From: Brereton, Steven [Steven.Brereton@lancashire.gov.uk]
Sent: 12 December 2012 11:02
To: Graeme Thorpe
Subject: FW: 12013 Carr Hall - 03/2012/0539 Revised LVIA document

From: Brereton, Steven
Sent: 11 December 2012 16:21
To: 'Graeme Thorpe'
Subject: RE: 12013 Carr Hall - 03/2012/0539 Revised LVIA document

Please see attached our revised LVIA document for application 03/2012/0539 for 3 x 36.4m wind turbines at Carr Hall. Please superseded our earlier submission.

APPENDIX 2
5KM ZTV DRAWING

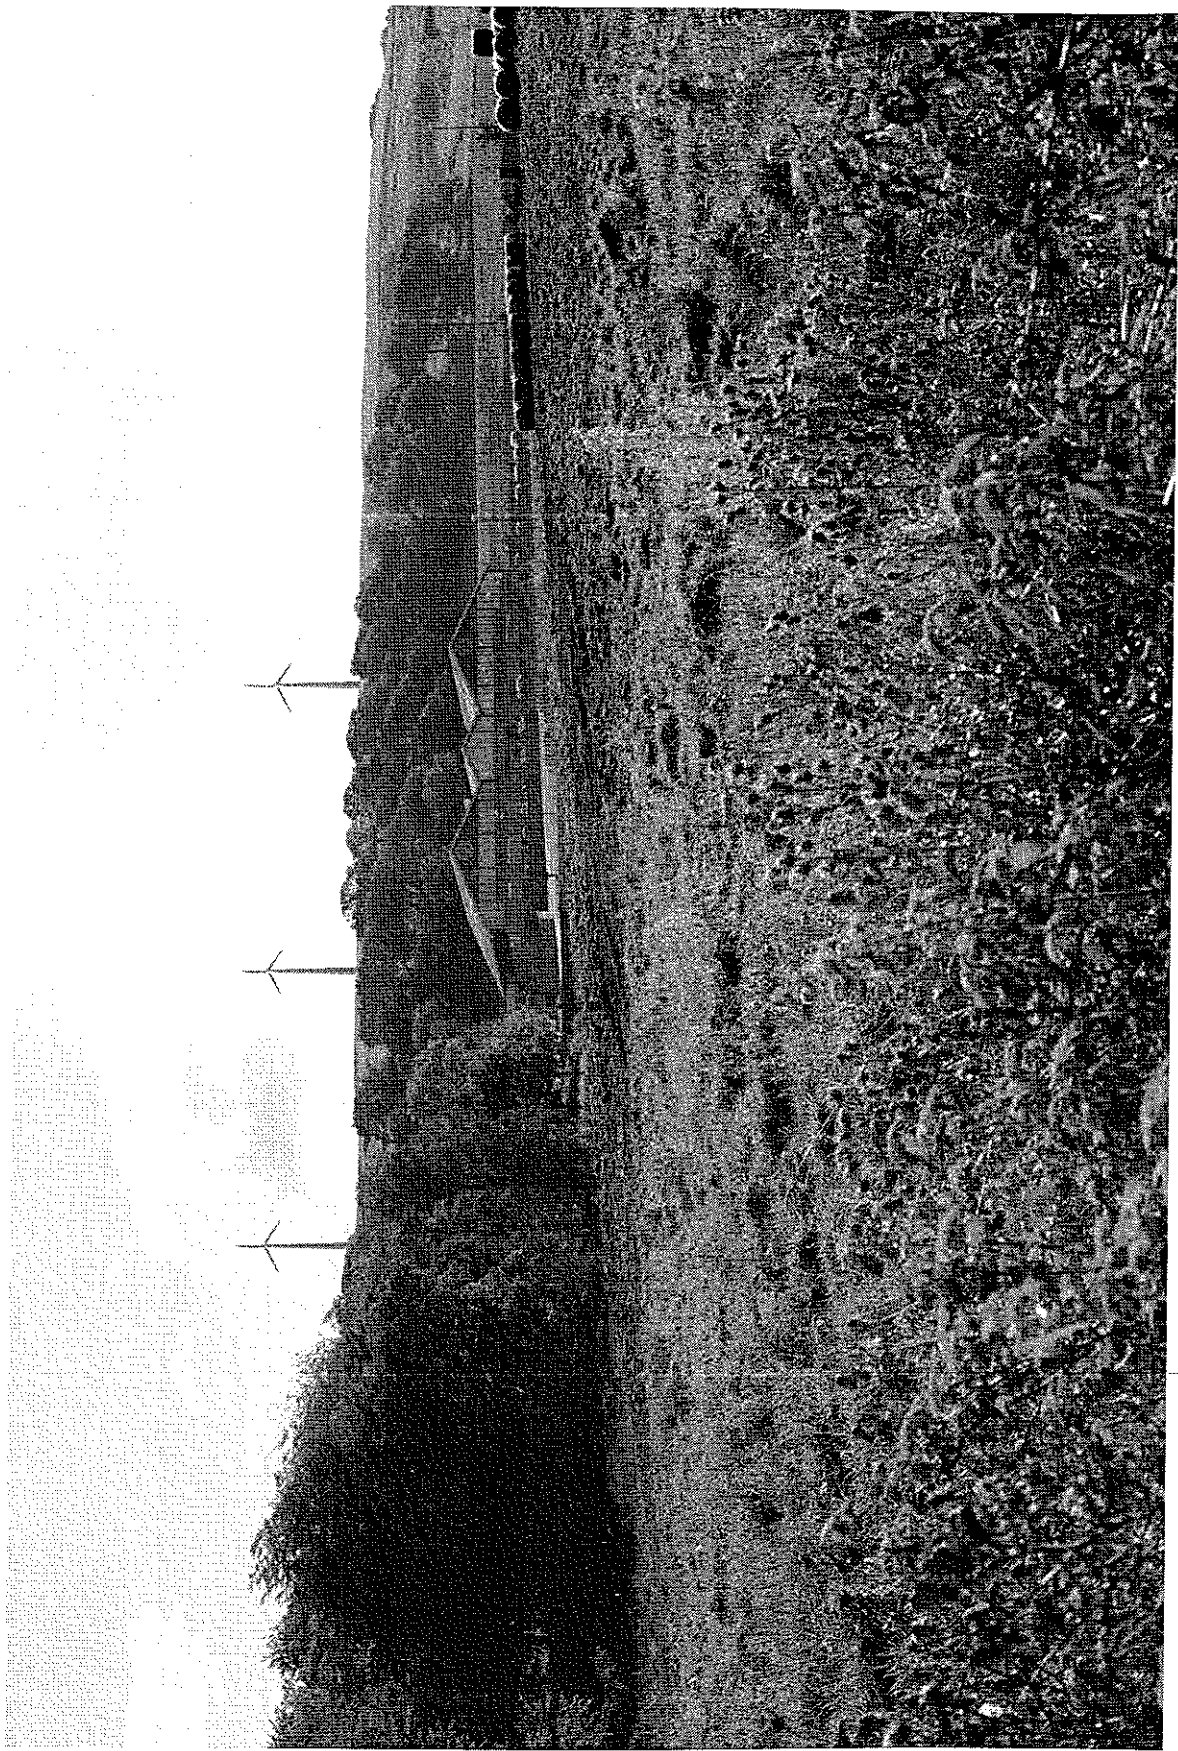
I previously commented on this application on 25th October 2012. Part of my comments drew attention to some of the weaknesses in the applicant's landscape and Visual Impact Assessment. Since then, a Zone of Theoretical Visibility (ZTV) map has become available. In the main this map appears to have been prepared in accordance with good practice guidance such as that contained in *Visual Representation of Windfarms, Good Practice Guidance, 29 March 2006* (Scottish Natural Heritage). There are however some aspects of the ZTV map which I am not happy with, the principal being:

- a) The ZTV map only covers a study area of just 5km radius. The SNH guidance referred to above recommends in Table 2 a study area radius of 15km for wind turbines up to 50m high. In my opinion the radius of the study area should be at least 10km as 3 turbines are proposed and it is important that highly sensitive and elevated landscapes within the Forest of Bowland AONB are included. It would have been helpful if the applicant had discussed his/her proposal for a study area of 5km radius with the local authorities before producing the ZTV map.
- b) Good practice requires the ZTV to show visibility to blade tip and to the hub (nacelle). The applicant has provided ZTV mapping to hub height only which means that a smaller area of theoretical visibility is shown.

VP2 View from Snodworth Road/York Road Junction

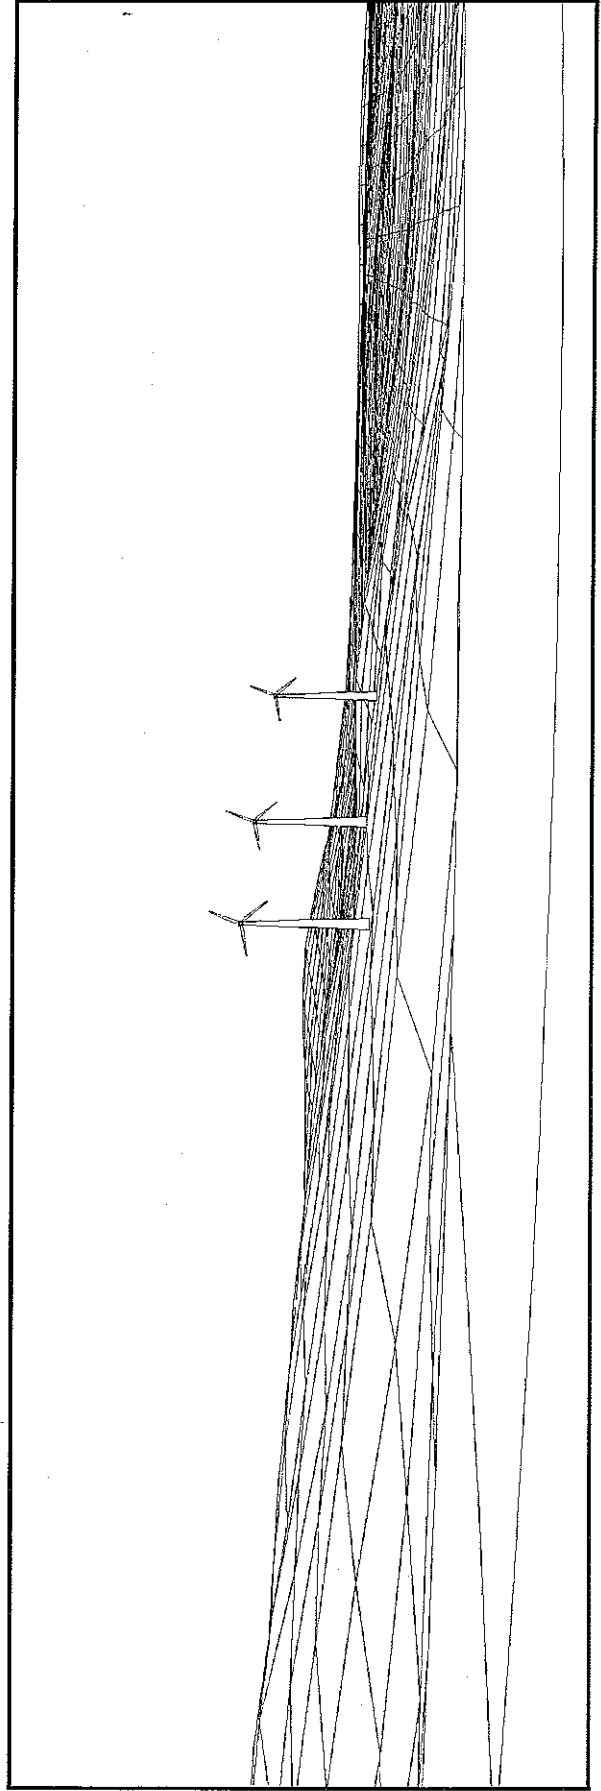
Aside from the production of a ZTV map, the rest of the applicant's LVIA is largely unchanged and the other issues I previously raised have not been addressed. Consequently the LVIA still incorrectly states that the County Council's landscape sensitivity study confirms that the landscape within which the application site is situated is capable of accommodating small to medium scale wind energy development. The photomontages continue to remain unusable as no information has been provided on how to use them and there is not even a viewpoint location plan. The absence of this and other key information undermines the validity of the photomontages making me question whether they have been produced in accordance with good practice. In addition I have reservations concerning the accuracy of the proposed wind turbine's height in some of the photomontages. It seems that the scale of the wind turbines may be being under represented. Taking VP2 for example, I note the following:

Turbine 3 would be situated at approximately 195m AOD. This means that the blade tip height would be 241m. To the south the land rises over Wilpshire Moor to a height of 233m some 8m below the blade tip of turbine 3. Despite this, turbine 3 appears to be below the summit of Wilpshire Moor in VP2.
